Harnett County Government Complex  
307 Cornelius Harnett Boulevard  
Lillington, NC 27546

**Re: Status of Improvement Permit Application #05-5-12235**

CRESTVIEW Lot 169

Required Changes In  
Home Set Backs

plot plan

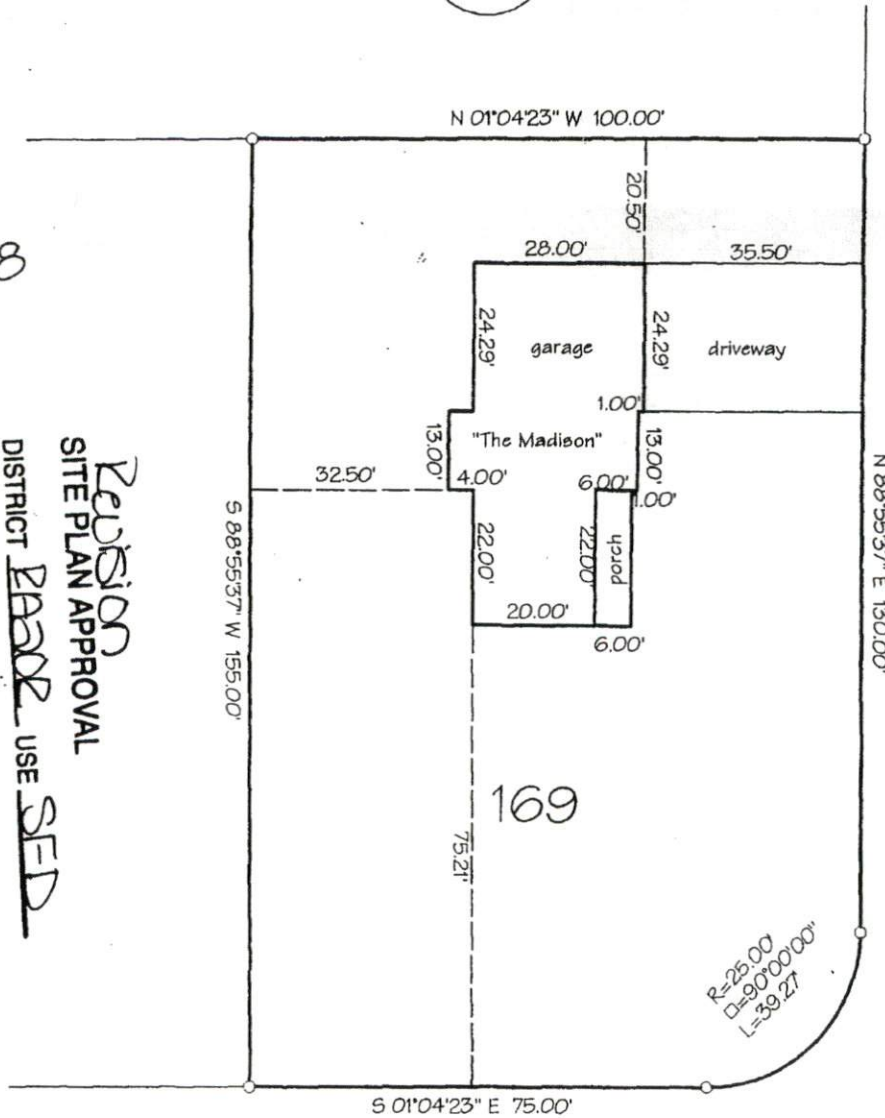
- 1. Property lines/corners not marked or labeled
- 2. House corners not marked or labeled
- 3. Directions not clear to property
- 4. Property needs brush or vegetation removed
- 5. Backhoe pits required
- 6. Other **Due to soil conditions you will need to move home. See attached sheet for new home set backs. Please submit changes to Central Permitting.**
